Planning Services Sign Permit Review Form

Date of Submittal	Application Number	Applicant	Landowner
3/10/2022	SIGN2203-0005	Signs of the Pines, Inc.	MDC NC3 LP

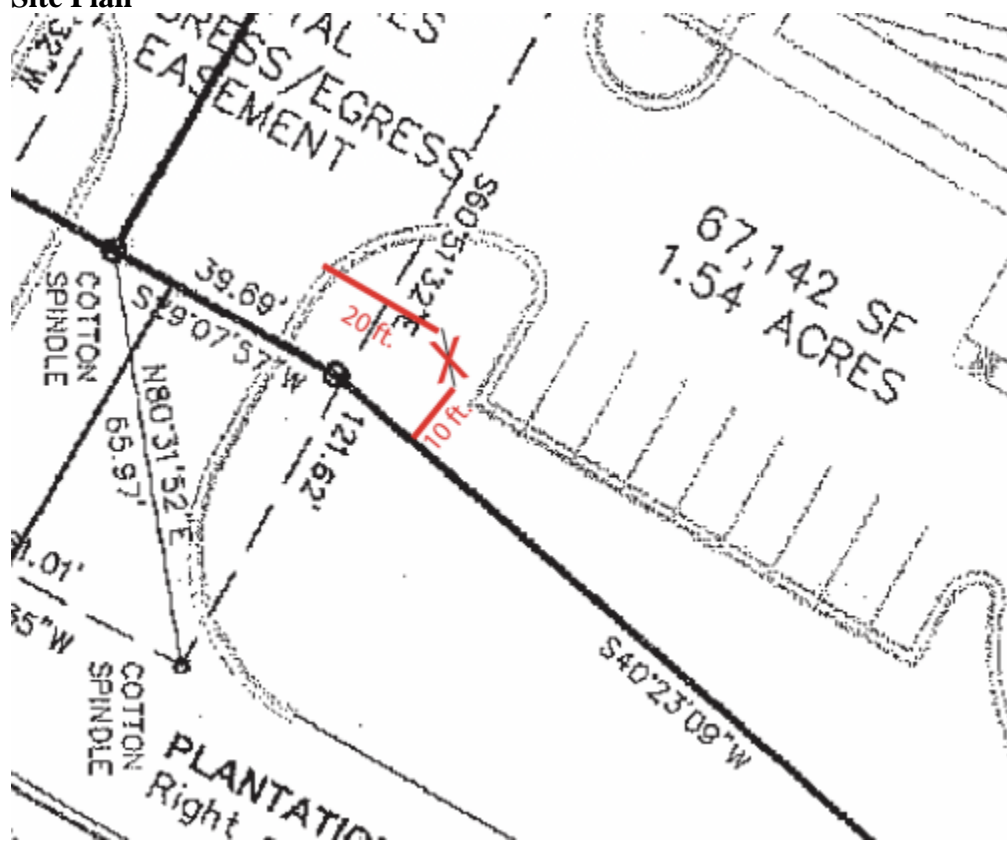
Comments	<ol style="list-style-type: none"> 1. Please submit a revised site plan with the setback legible. 2. Please submit a revised rendering of the sign that includes the overall height of the sign, and the height and width of the sign copy area. The information provided on the land use application does not appear to match the rendering and was not clear.
----------	---
